**Consultation Response from KC,  
Lead Local Flood Authority**

**2025/93229 Land off, Westgate, Cleckheaton, BD19 5DR**

**Discharge of details reserved by conditions 15 (drainage), 33 (waste), 37 (cycle parking), 41 (LEAP) on previous permission 2021/93567 for demolition of existing commercial buildings and erection of 180 dwellings with associated works**

**Date Responded: 30<sup>th</sup> December 2025**

Client	STRATA HOMES		
Project	WESTGATE, CLECKHEATON		
Title	FLOW CONTROL		
Drawn	FA	Checked	ND
Date	16.02.2022		
Drawing Number	QD1776-08-03		
Drawing Status	CONSTRUCTION	Scale	1:25 - A1
Rev	H

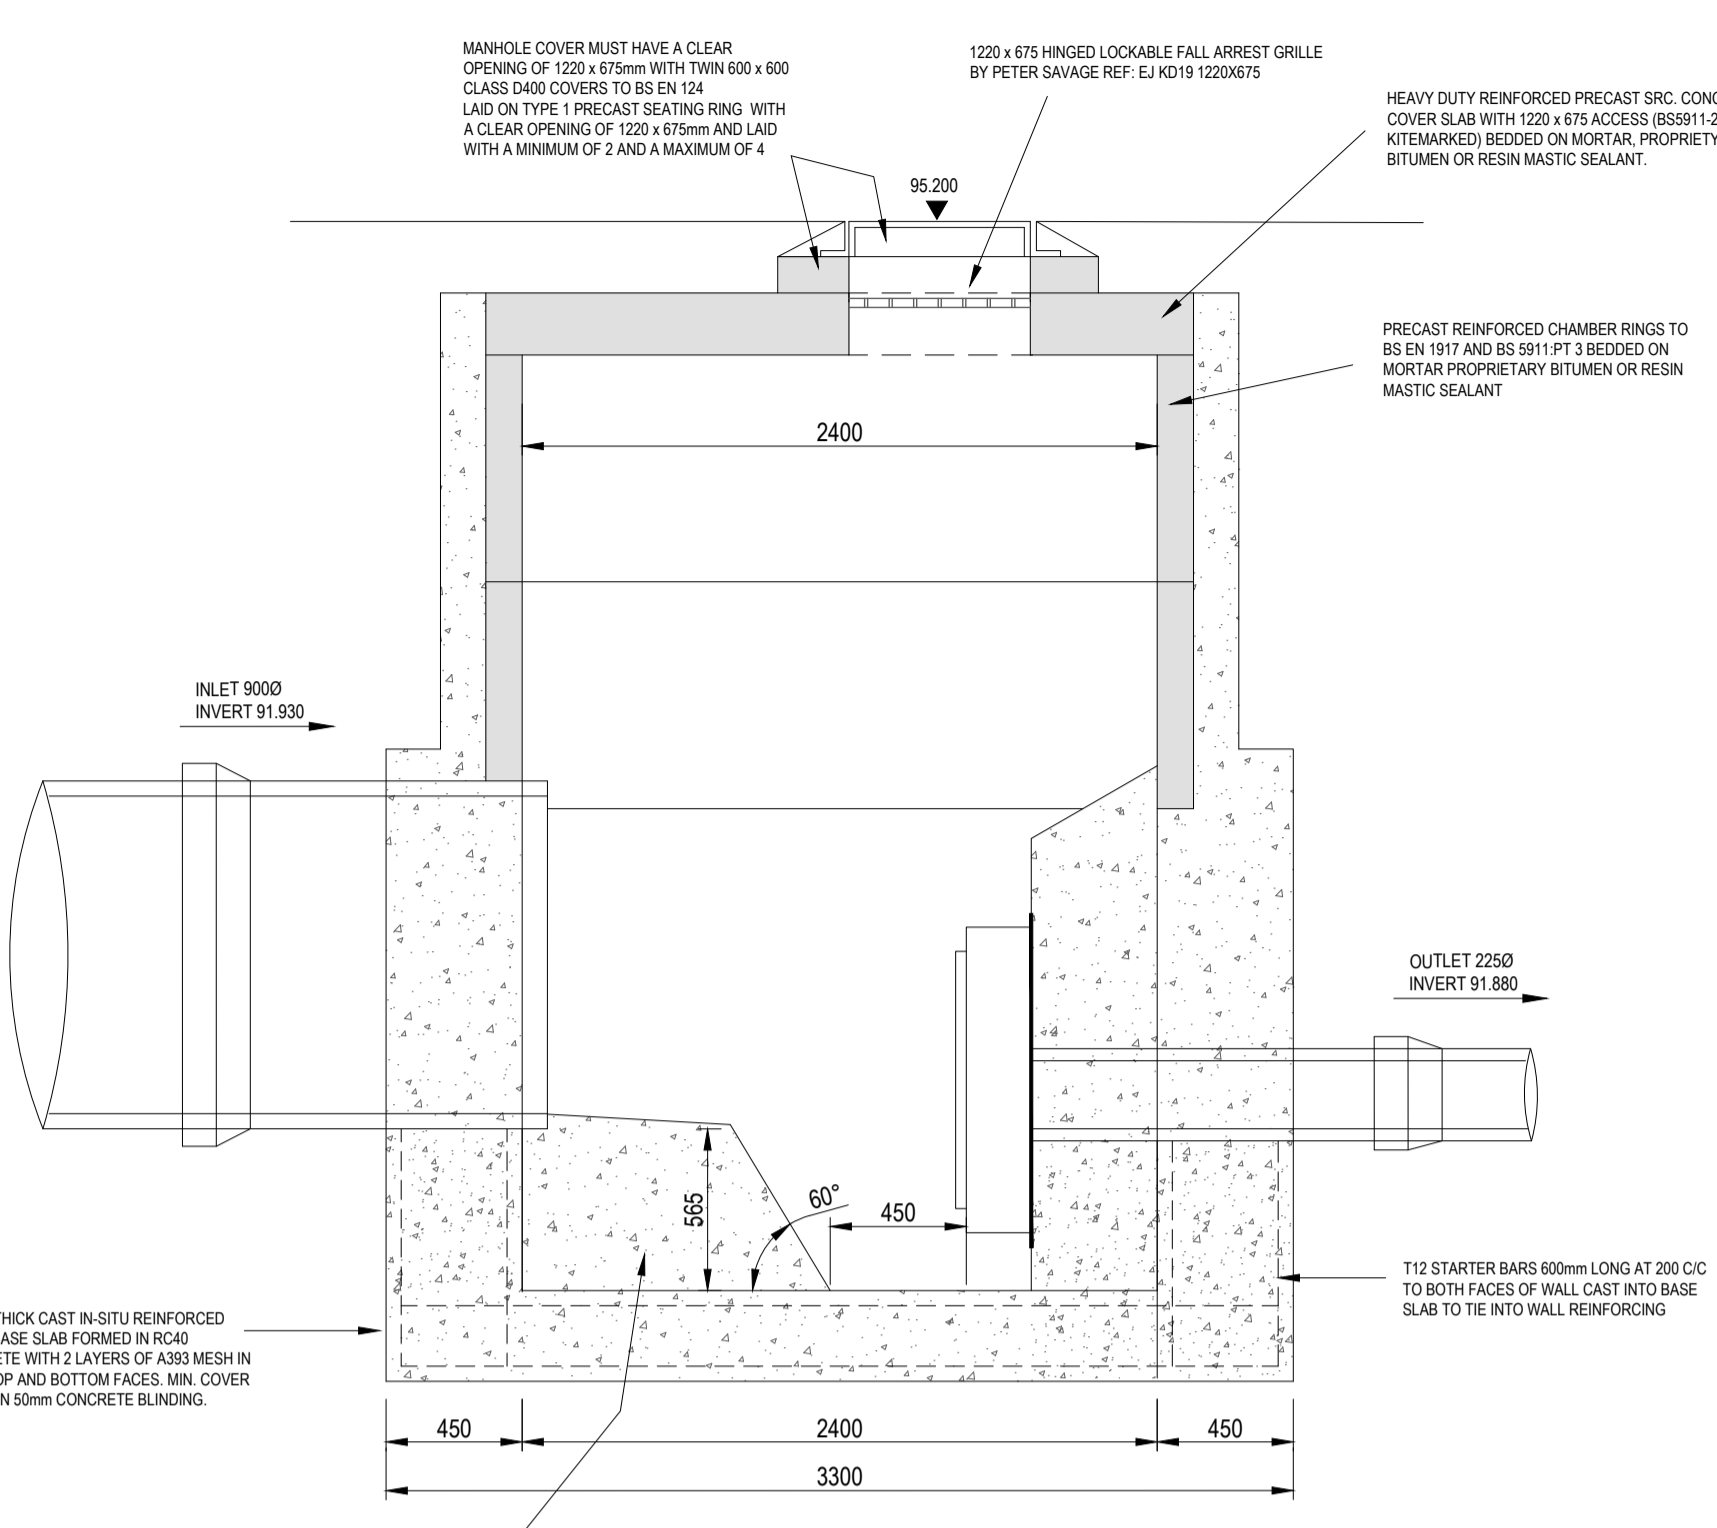
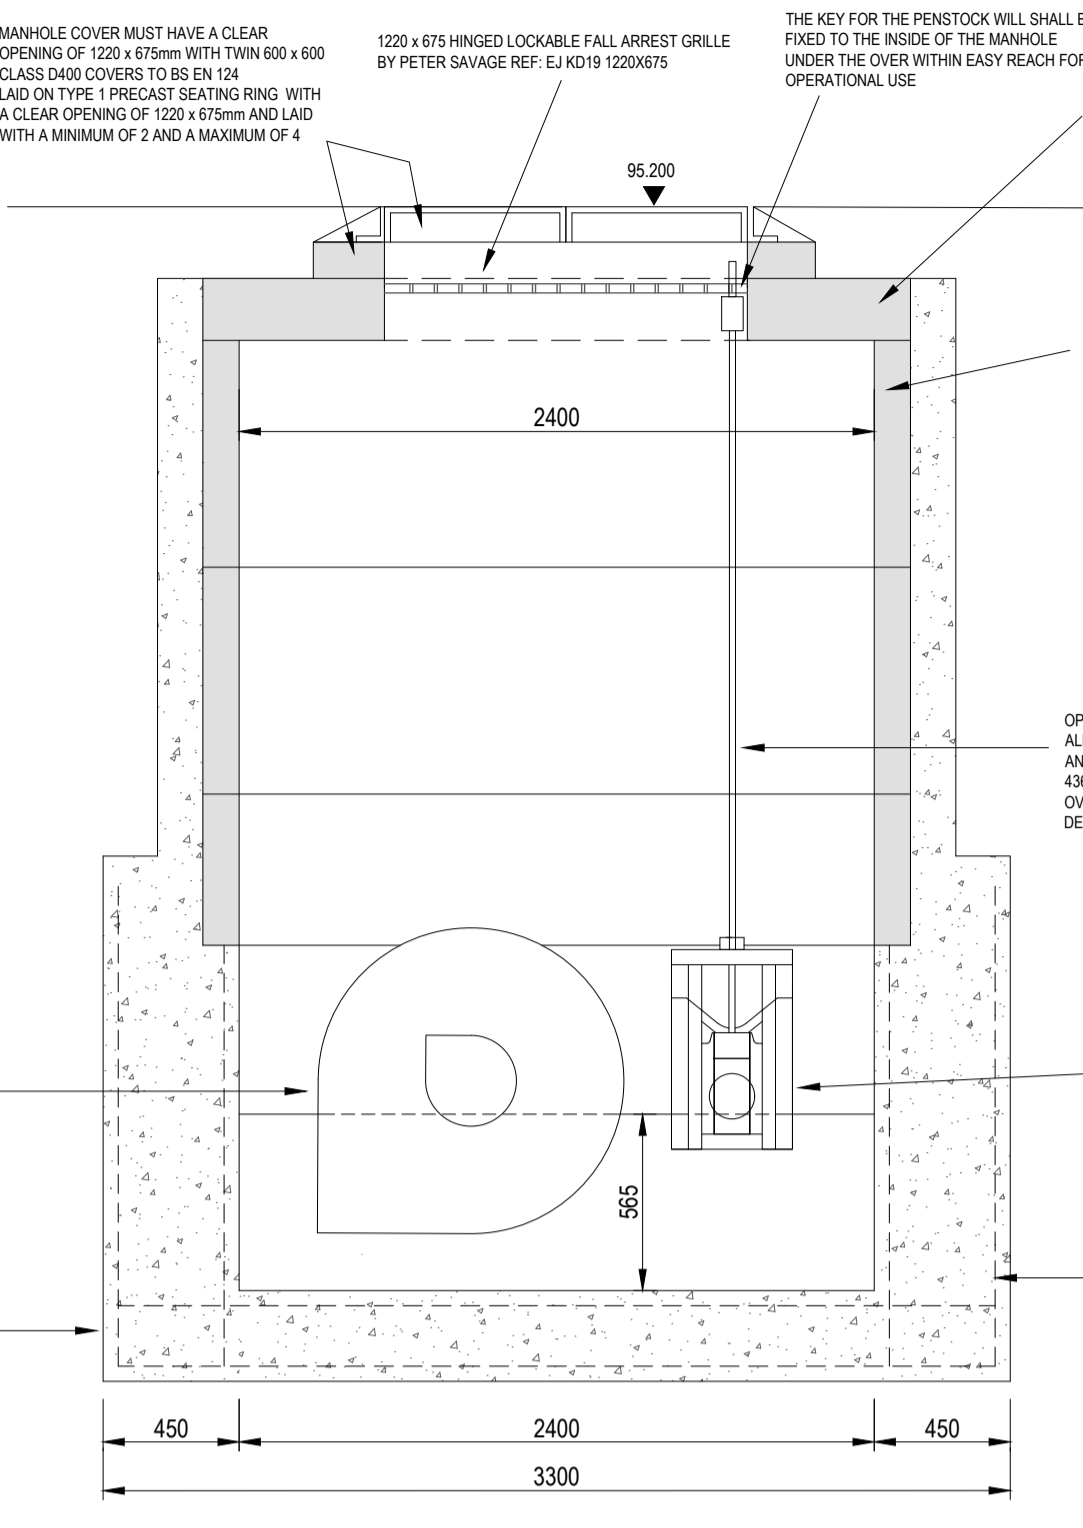
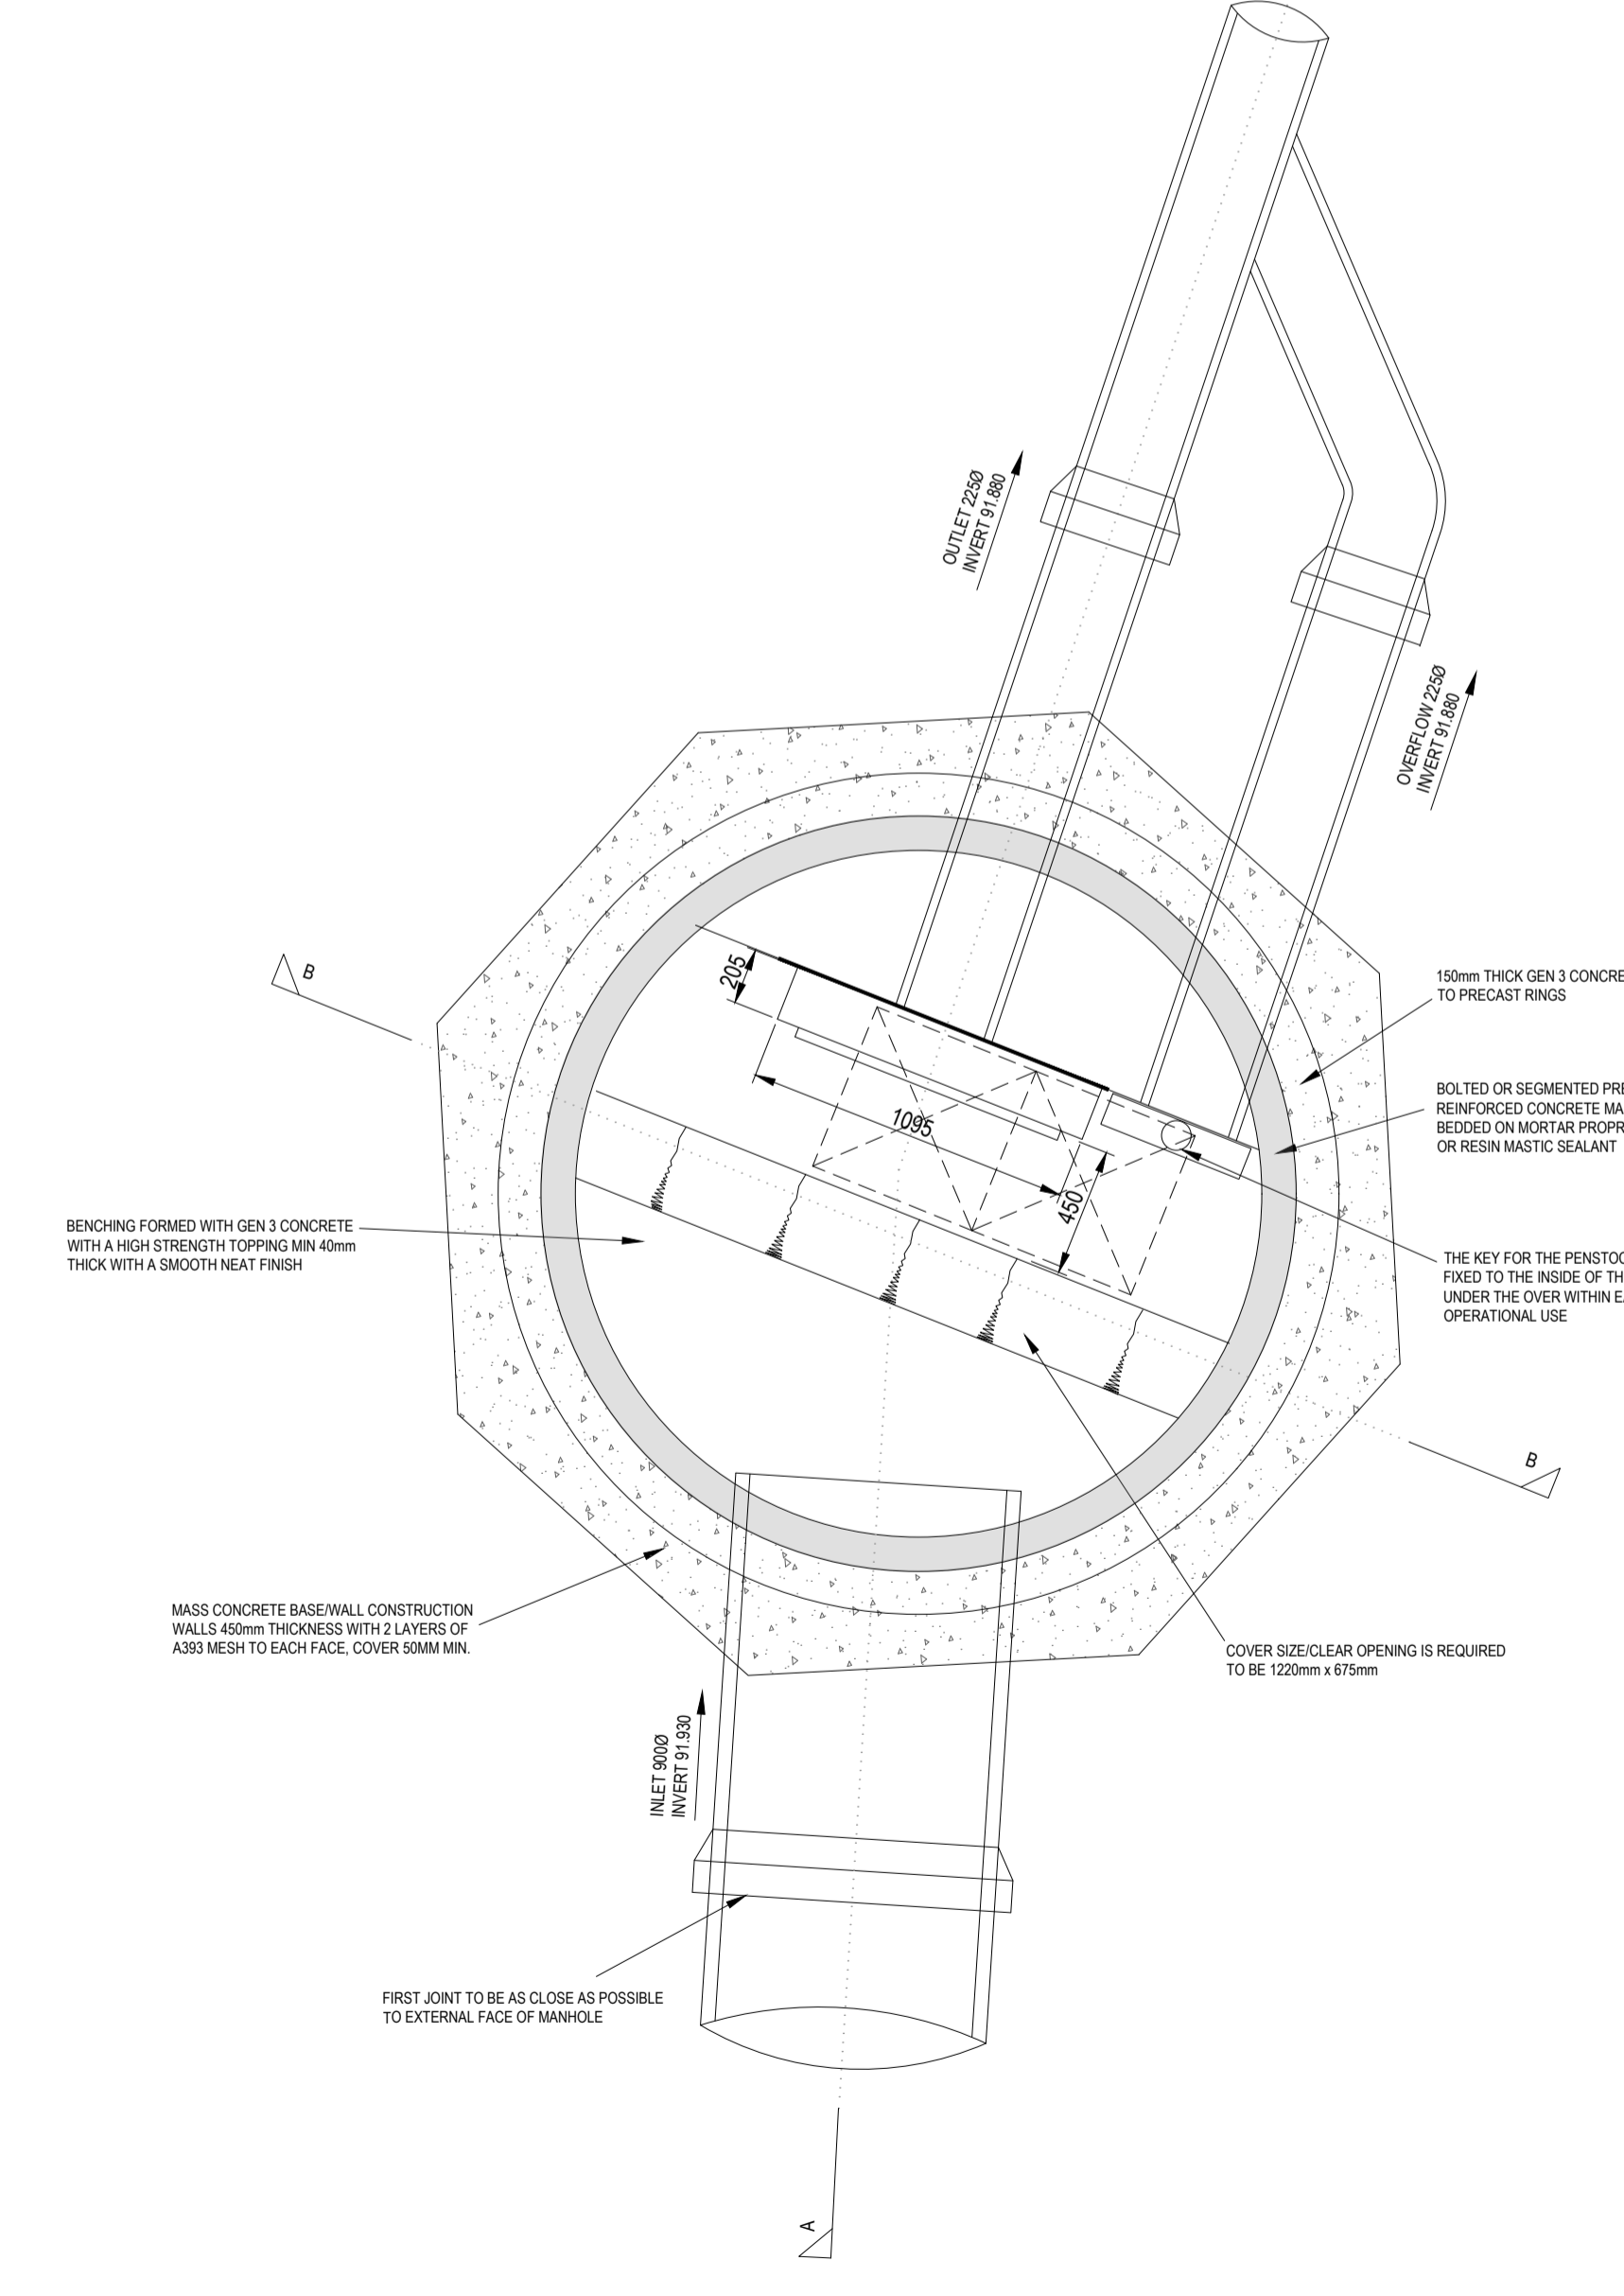
For the flow control device, the penstock will likely need greasing periodically to ensure it does not stick. The flow control device may need to be removed at some point, and the neoprene seal must be replaced at this point. Sumps must be cleared periodically and the methodology and plant required must be stated.
